RE: 65 Munjoy St. development project.

I have briefly reviewed the plans and other information that you forwarded regarding the 65 Munjoy St. project. I understand that you are trying to provide comments to the developer and the city so they may benefit from public input into the process. Here are my comments on the design of the project, which you may feel free to share with others.

DRAWN BY
EAC
 SHEET TITLE
FIRST FLOOR & SITE

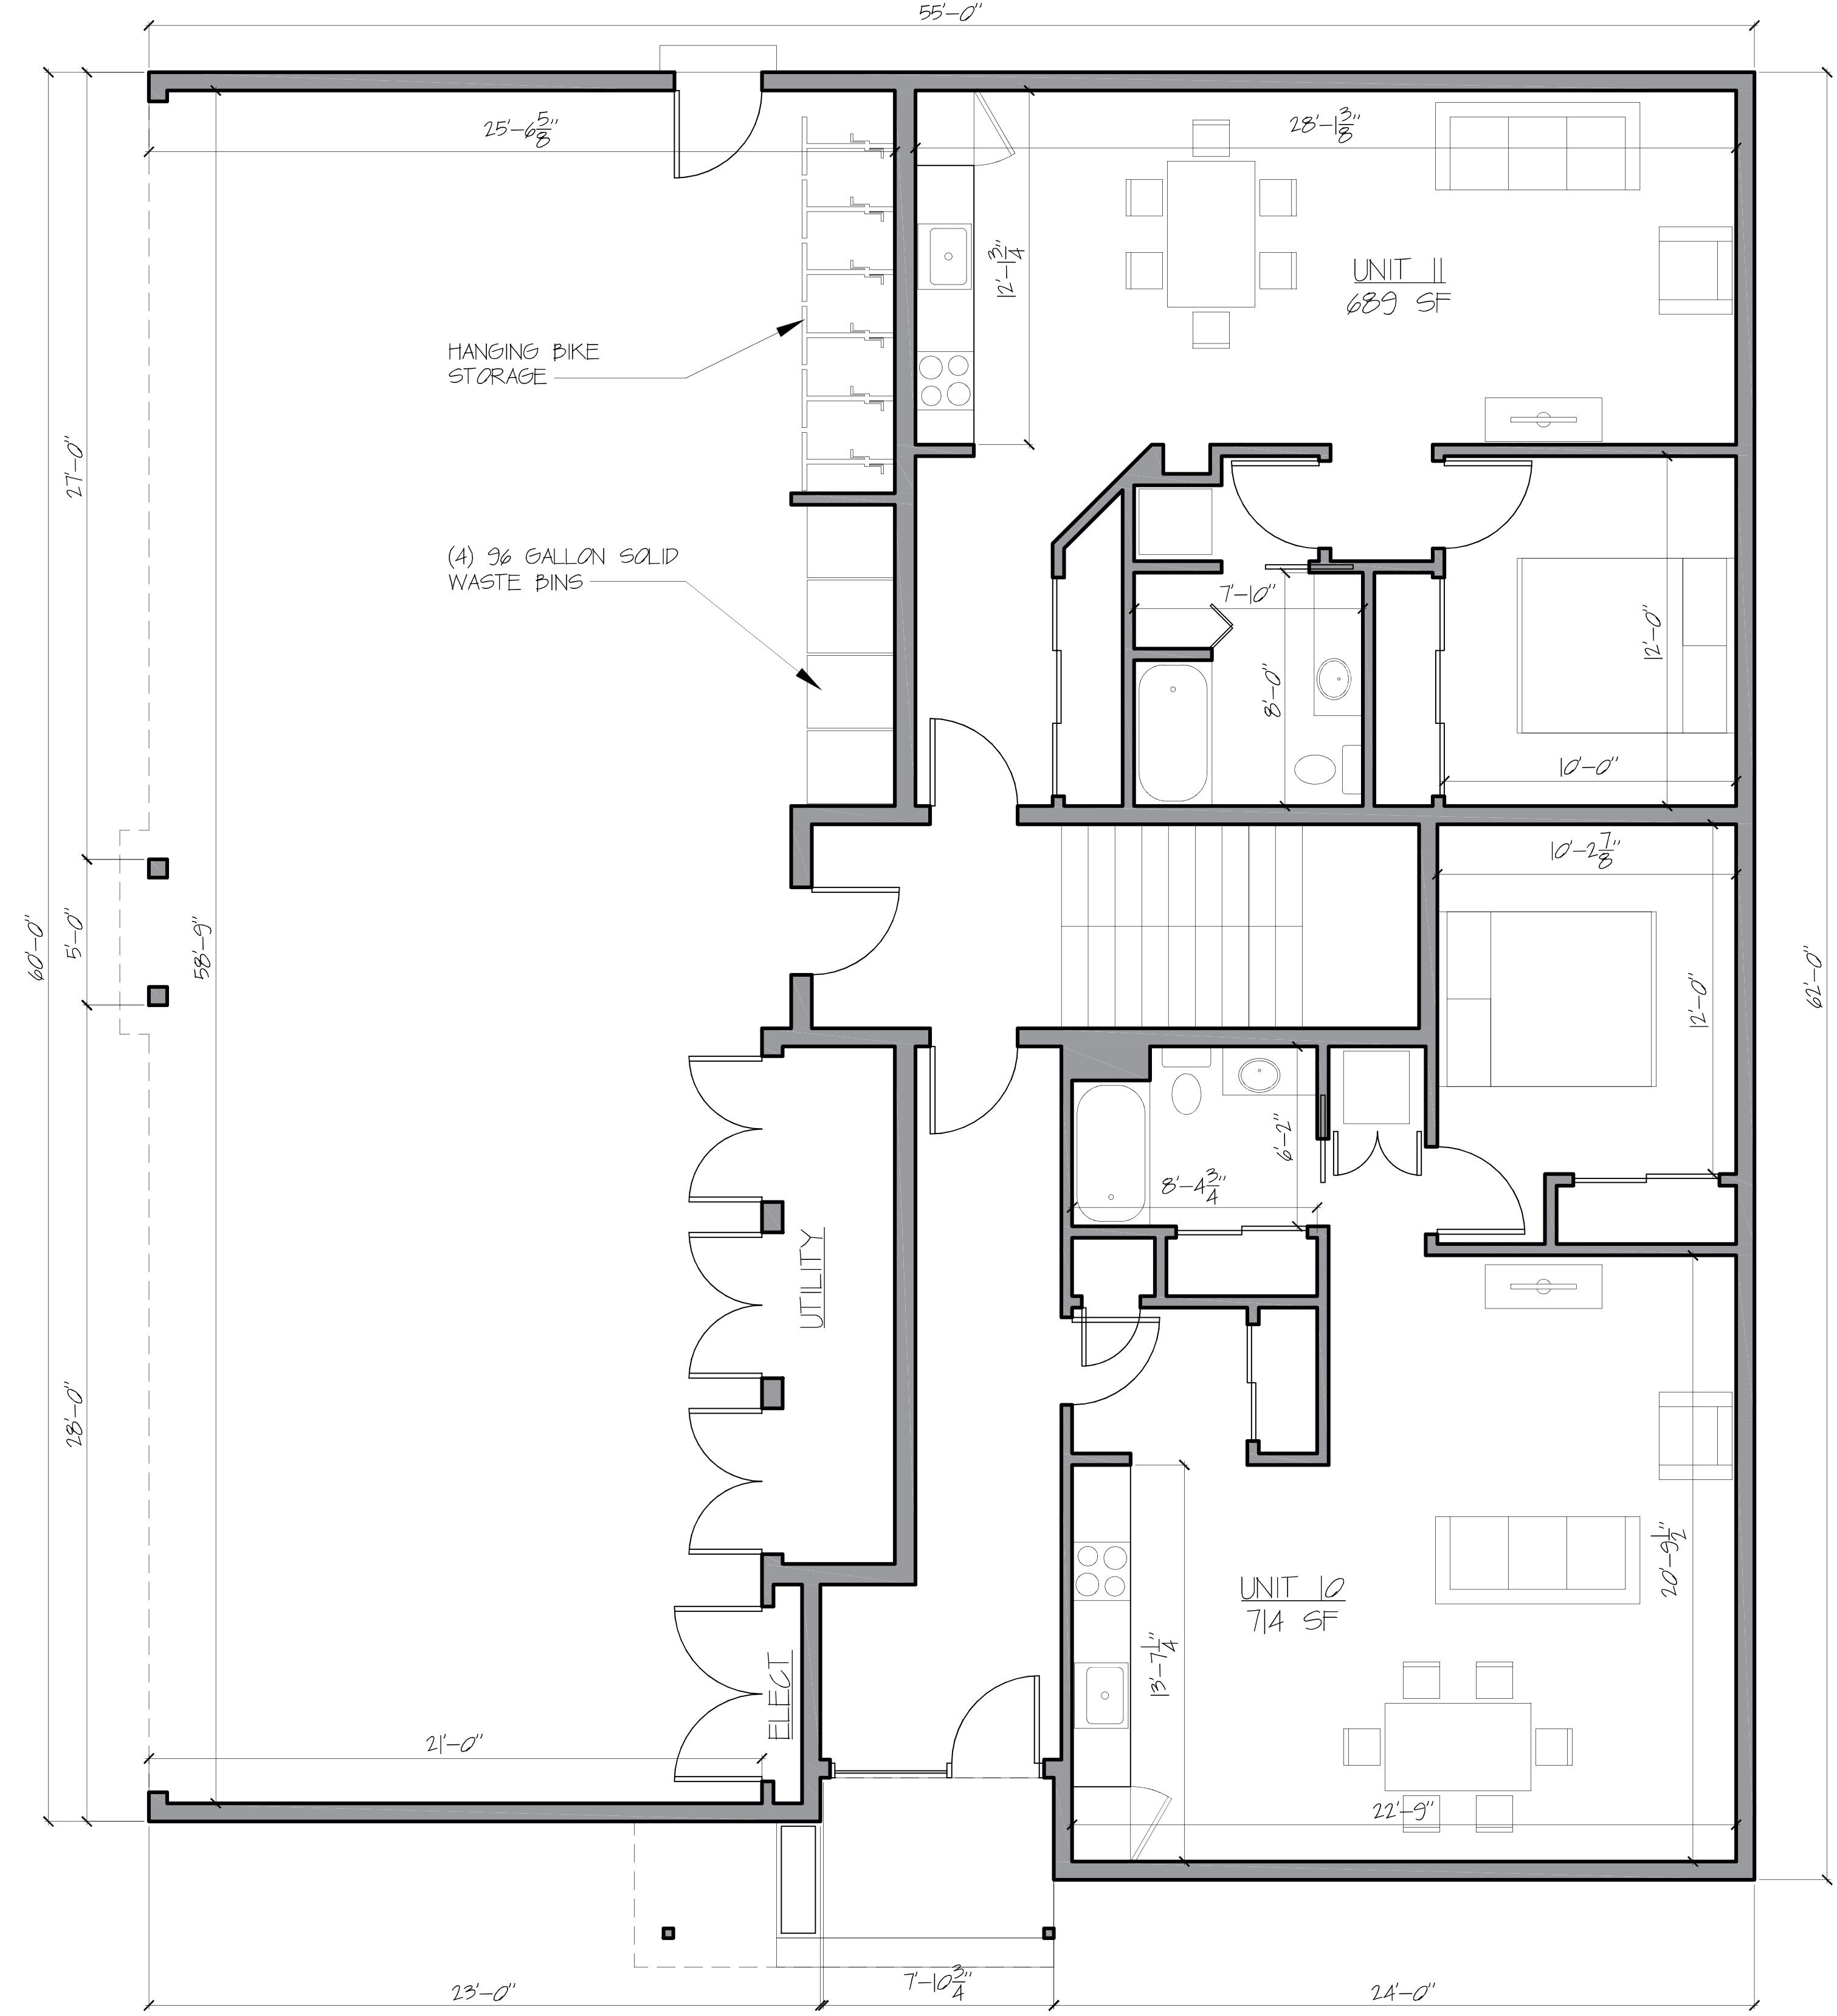
- Eight units is very dense for this site,
- The site plan would be improved if usable open space could be increased on the site.
- No handicapped units are shown on the ground floor. Confirm that this would comply with Federal Fair Housing Act, and HUD 504 regulations. (I don't think it does.)
- No handicapped parking spaces are shown, as far as I can tell. Again confirm this complies with Fed Fair Housing Act and HUD 504. (I don't think it does.)
- Could the 2 parking spaces facing Adams Park be eliminated? (They have a very long back-up route to get out of those spaces.)

- Consider changing small windows at 1st floor to taller, vertical windows, even though they go into the parking area they would be more in character with other windows on the street front.

**CONCEPT DOCUMENTS ELEVATIONS**

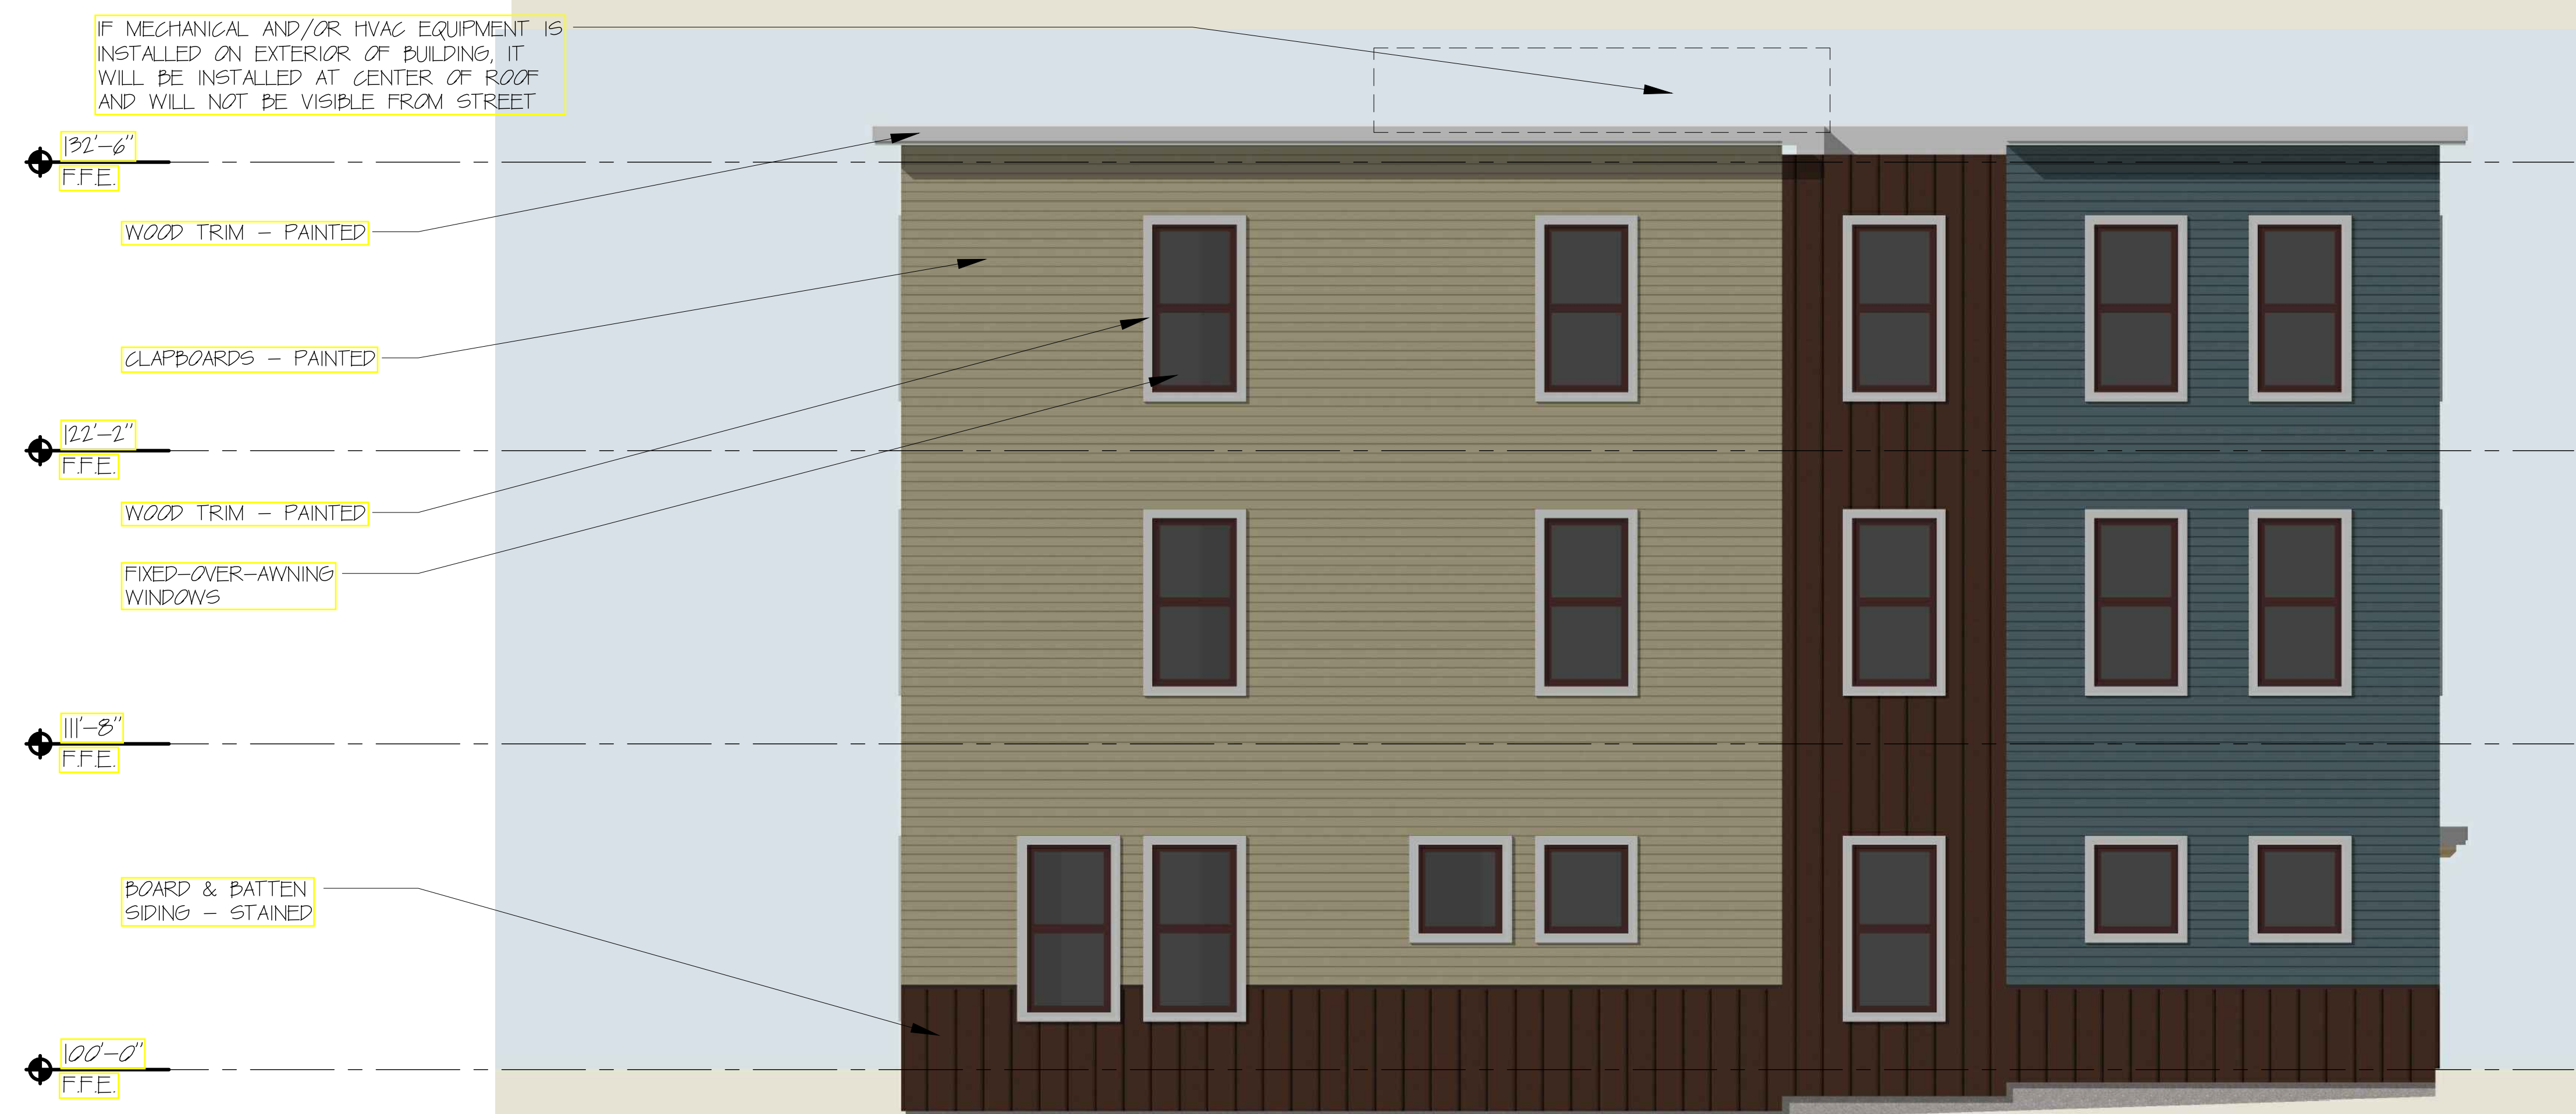
- Consider providing better buffering between sidewalk and building front wall at ground level.
- Consider changing the massing of building so facade is not as wide so close to the street. Perhaps more of an “L” shaped plan. Perhaps build over the parking/driveway at the rear of the lot, so the front facade could be more vertical and narrower.

- Consider more detailed wood work at the bay windows. The detailing could be more contemporary or it could be historic, but the purpose is to modulate and identify the bay as a feature...

- Consider pairing, or grouping other windows on the front facade to provide more interest, variety, less uniformity. (Also note windows shown on elevations do not correspond to windows shown on plans.)

- Consider using a different coursing (spacing) of the clapboards at the first floor level to add interest to the texture of the building.
- Consider other ways to break down the scale of the facade with step backs, recesses, and the use of colors to reduce the “boxy-ness” and mass of the facade.
